Rezoning Transportation Analysis

Petition Number: 2020-043

General Location Identifier: Tax ID 21159315

Date	Description
04-21-2020	First Review

REA COLONY STORAGE 4245 REA ROAD CHARLOTTE, NORTH CAROLINA	
CONDITIONAL REZONING SITE PLAN	
	3630 CLEMMONS RD., #1761 CLEMMONS, NC 27012 (813) 310-8520 (PH) (813) 746-4663 (FAX)
PRELIMINARY NOT FOR CONSTRUCTION	DATE: 02/24/2020 SHEET RZ-1

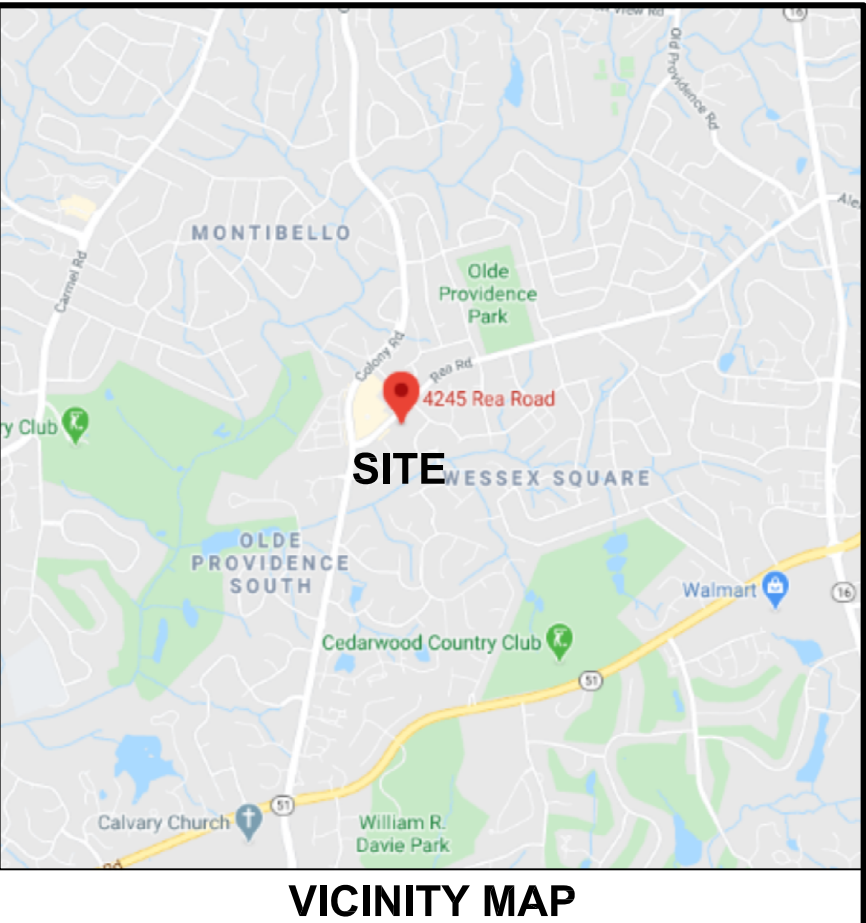
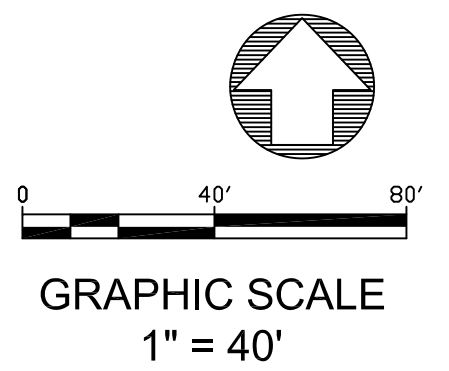
The site is located on a minor thoroughfare. The petitioner should update the site plan and conditional notes committing to a 12' multi-use path, in lieu of the 6' sidewalk, along the site's frontage to accommodate bicycle connectivity. The petitioner should revise the site plan to meet the ordinance requirements and the outstanding items listed below.

1. **Curbline** The proposed zoning district has a setback measured from back of the existing or proposed future curbline.
 - a. **Rea Road:** The existing curb and gutter should be relocated 16.5' from the centerline of Rea Road. The ultimate cross section will include an 11' southwest left-turn lane, 11' travel lanes, 2.5' curb and gutter, 8' planting strip and 12' multi-use path.

The site plan should show the curb and gutter labeled and dimensioned from the road centerline.

2. **Traffic Study** It has not yet been determined whether a Traffic Impact Study is required for the complete review of this petition due to insufficient data received for the Indoor Storage. If during the permitting process the site generates more than 2500 daily trips, then a traffic study will be required.
3. The petitioner should update the site plan and conditional notes committing to a 12' multi-use path along the site's frontage to accommodate bicycle connectivity along Rea Road to meet the City's Charlotte BIKES policy. The streetscape should include an 8' planting strip and 12' multi-use path along the property's frontage on Rea Road.

4. The petitioner should revise the site plan and conditional note(s) to include a 50' minimum driveway stem from the right-of-way.

5. The petitioner should revise the site plan to add a note specifying dedication and fee simple conveyance of all rights of way to the City before the site's first building certificate of occupancy is issued. CDOT requests right of way set at 2' minimum behind back of multi-use path where feasible.
6. The petitioner should revise the site plan to add a note specifying all transportation improvements will be approved and constructed before the site's first building certificate of occupancy is issued. The petitioner may phase transportation improvements if said improvements and phasing are explicitly described in site plan notes.
7. ~~Resolved Sample format for comment that is resolved~~
